DRB Project Case #: 1009814

Subdivision Name: ALVARADO GARDENS UNIT 1 / LOTS 23A1A1, 23A1A2 & 23B1A1

DRB CASE ACTION LOG - BLUE SHEET

Application #: 13DRB-70666

# PLAT OF LOTS 23-A-1-A-1, 23-A-1-A-2 AND 23-B-1-A-1 ALVARADO GARDENS, UNIT 1

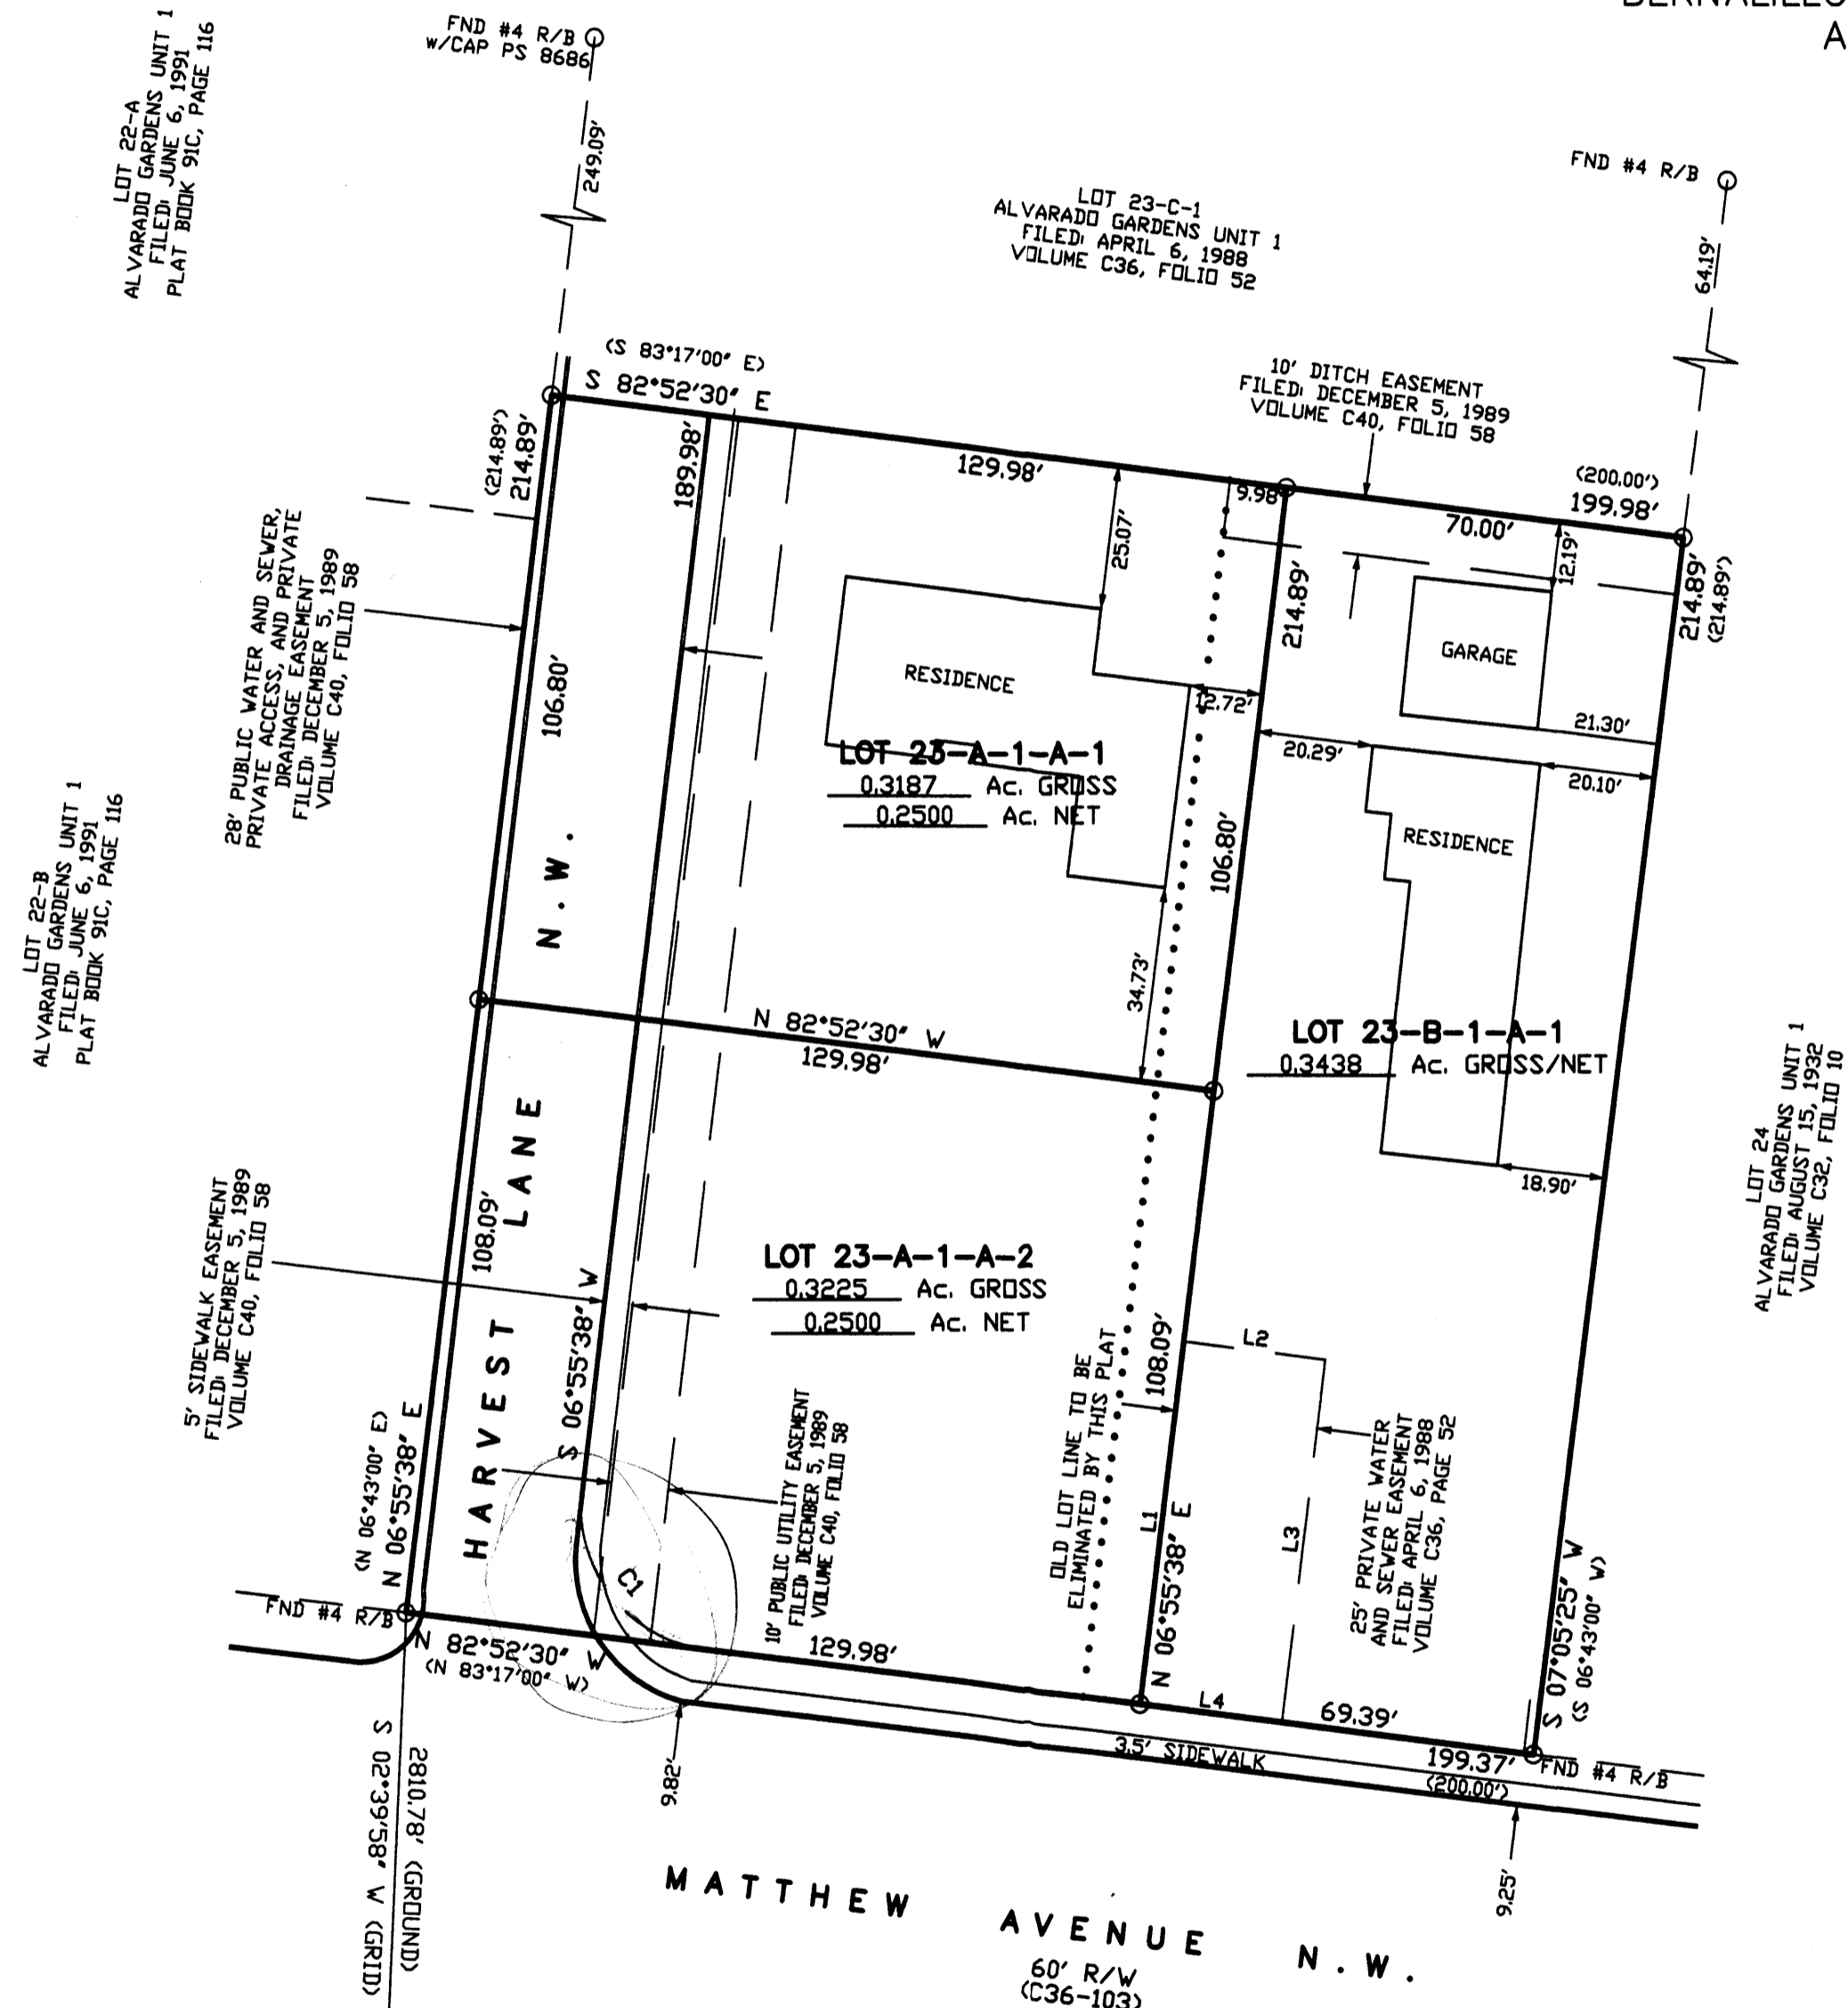
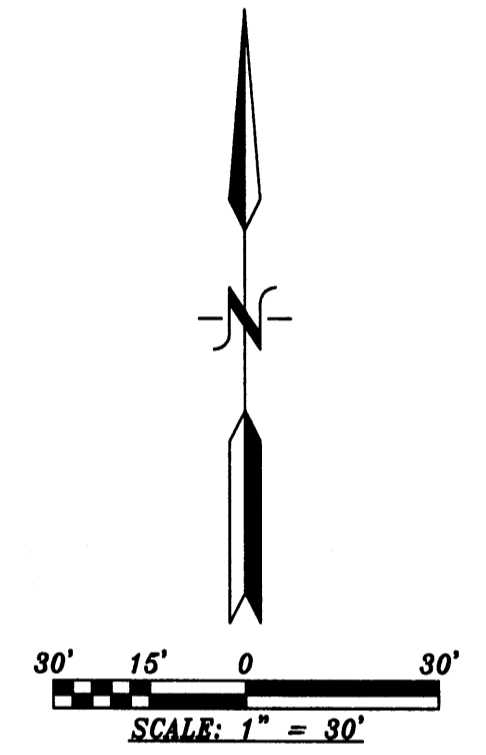
TRANSPORTATION: provide exhibit show adequate sidewalk easement
